Application for a non-material amendment following a grant of planning permission.

Replacement of unauthorised existing flat roof with a new pitched roof over a ground floor south facing outrigger. Resubmission of 3/2020/0353 & 3/2020/0895.

Reference number: 3/2021/0032

Amendment to vary the given drawing numbers and change the proposed overhanging gutter detail along the party wall between properties 2 and 4 Pendle Street West. The proposed design will include removal of the existing stone gutter and to replace for new powder coated profiled aluminium gutter at the head of the wall, with a drip flashing to conceal the junction between the two.

Drawing Title
Proposed Eaves Detail
Project
2 Pendle Street West, Sabden
Client
Jigsaw Homes Group
Scales @ A2
1:20
First Issue Date
06 / 10 / 2020
RIBA Stage - Drawing Status
[3] - Planning
Drawn
BB
Check
BY

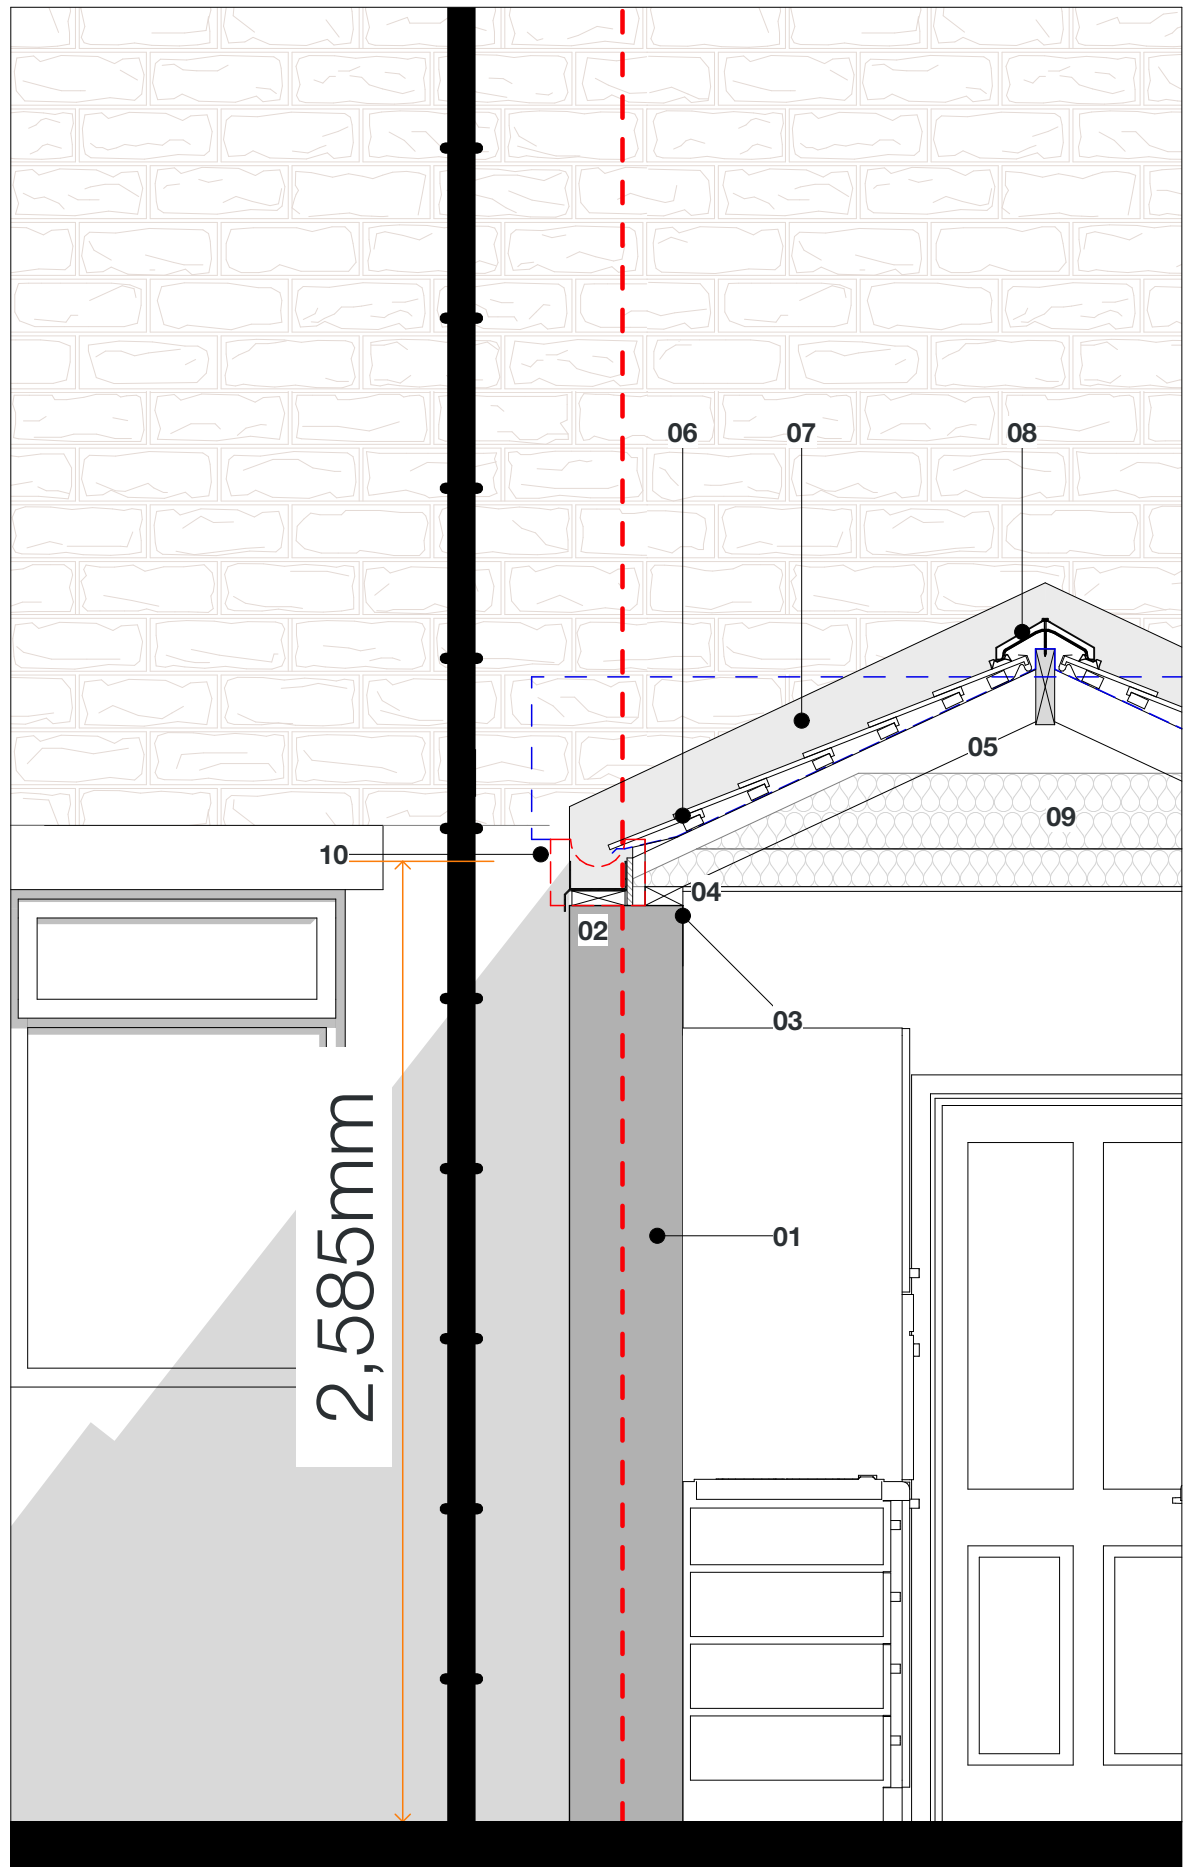
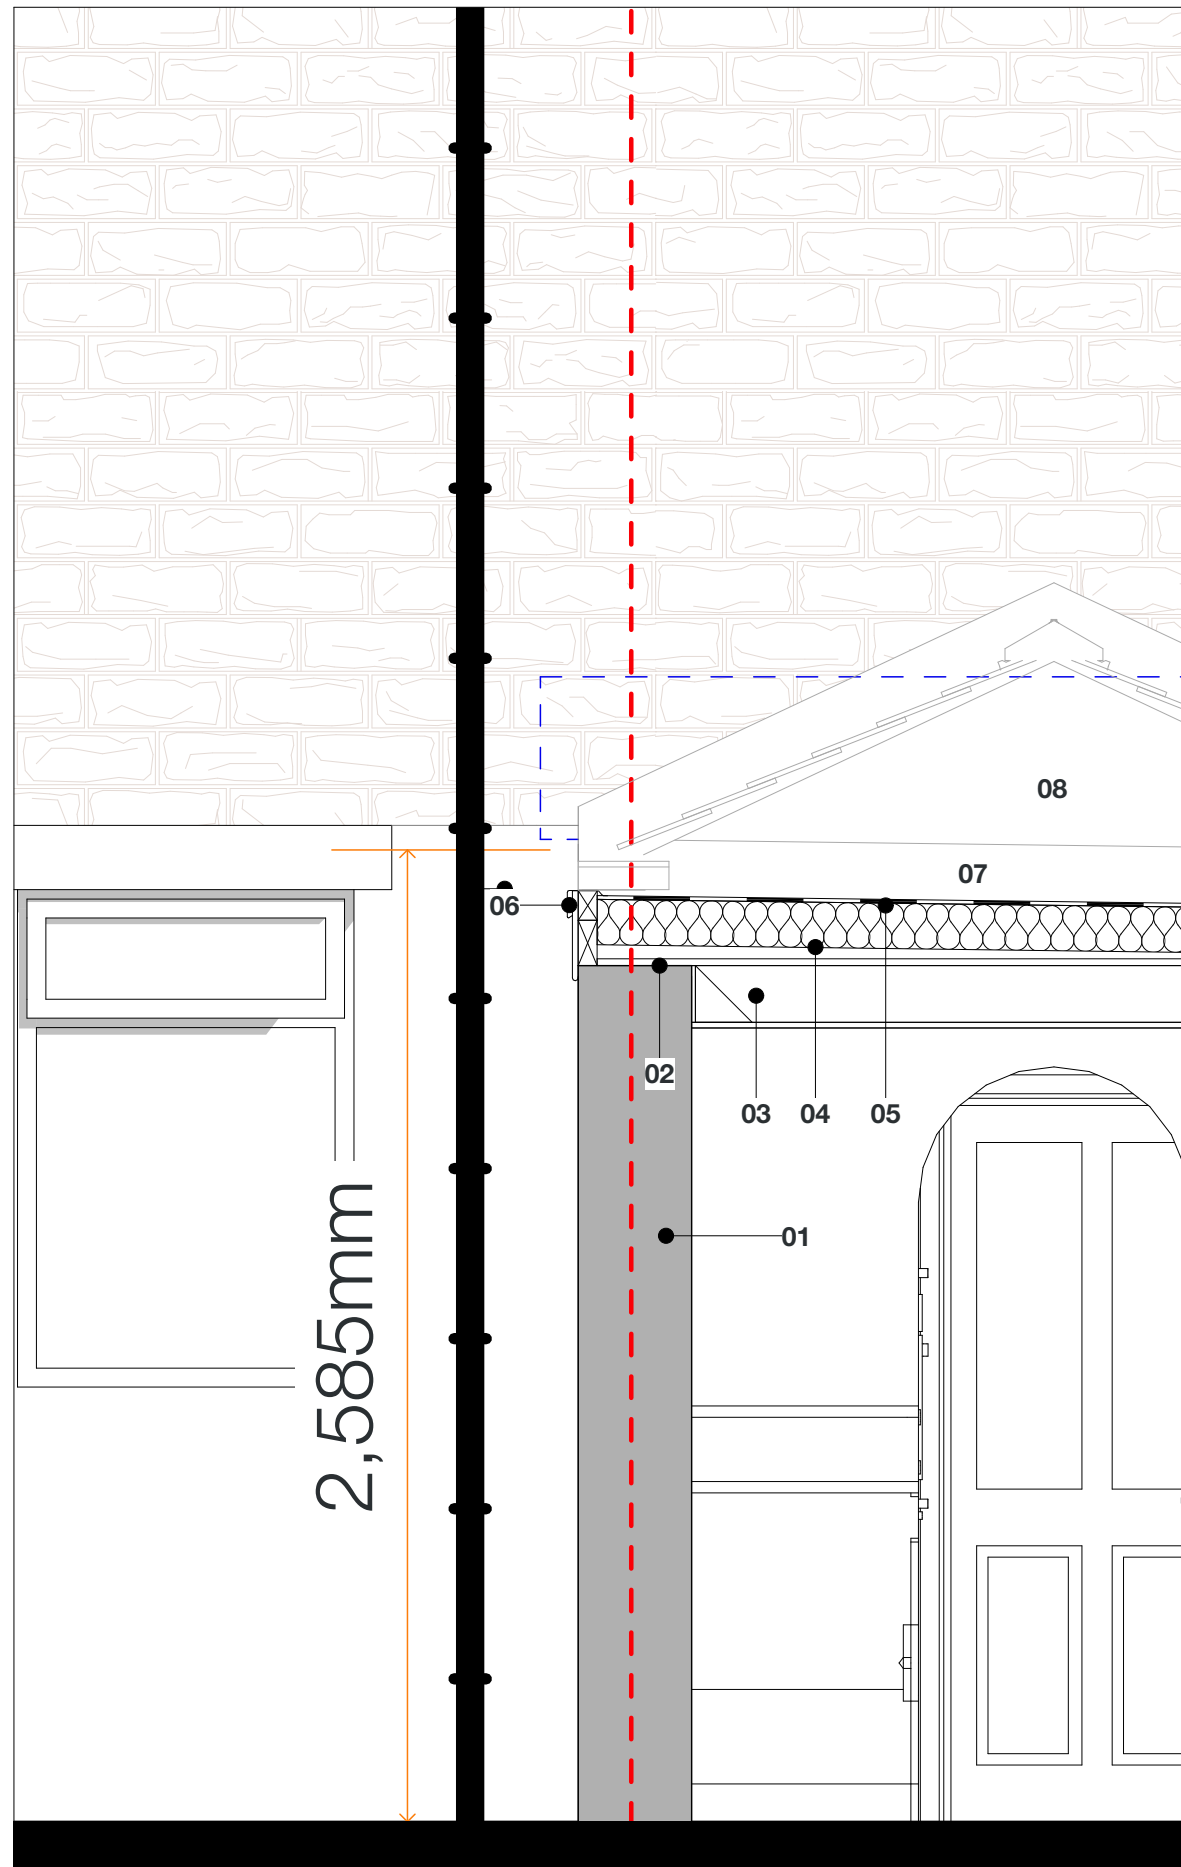
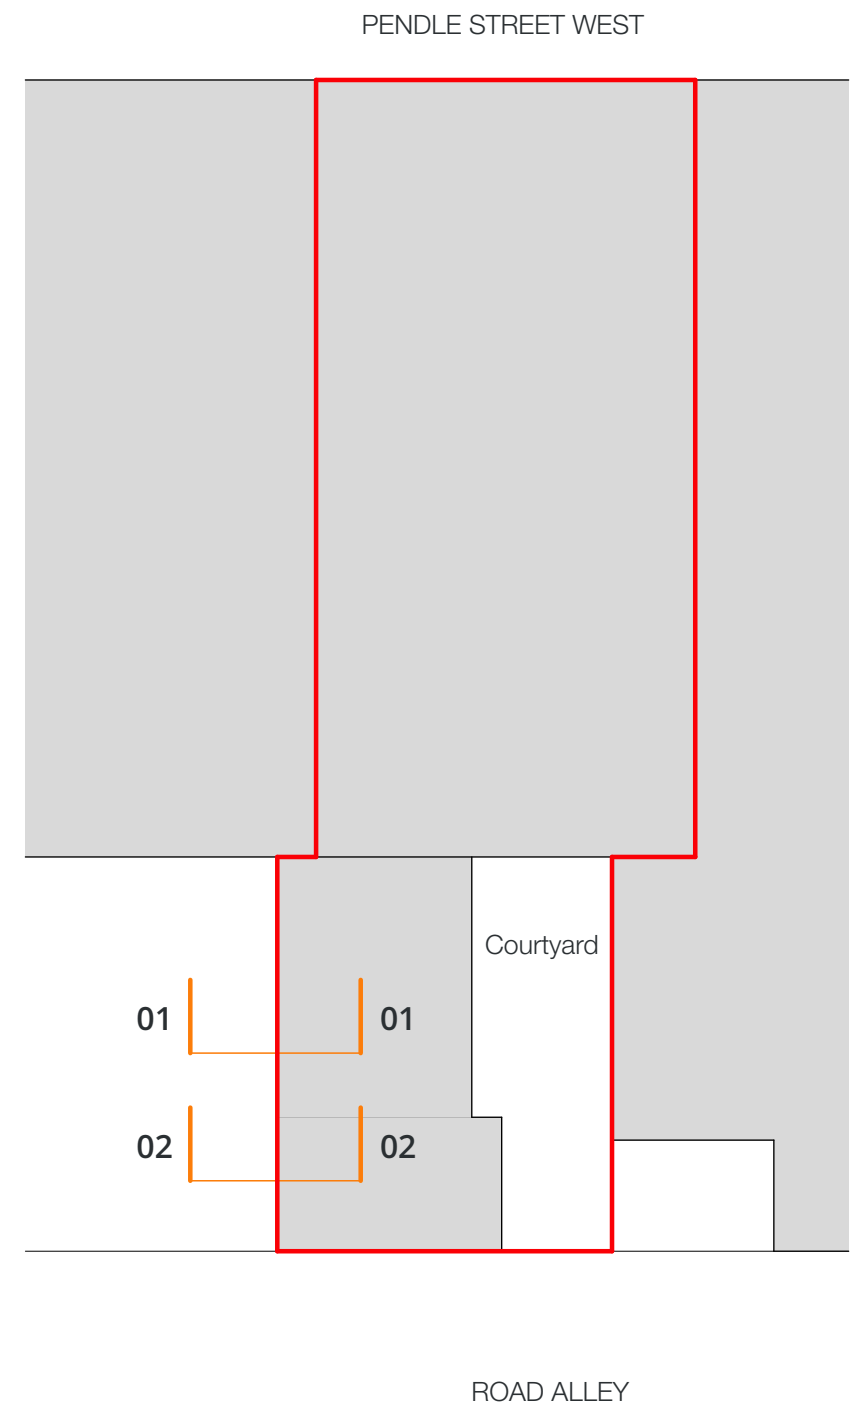
Concerns have been raised by the adjoining owner about the maintenance and visual aesthetic of the approved design which features and overhanging gutter along the party wall. The proposed solution is to replace this for a flush mounted gutter at the head of the wall. To minimise the visual impact of the proposals, the existing stone gutter will be removed and the top of the wall made good with the new gutter fixed in place and laid to falls. A colour matched aluminium drip flashing will cover any gaps between the new gutter and masonry below. All as per the details on the submitted drawings.
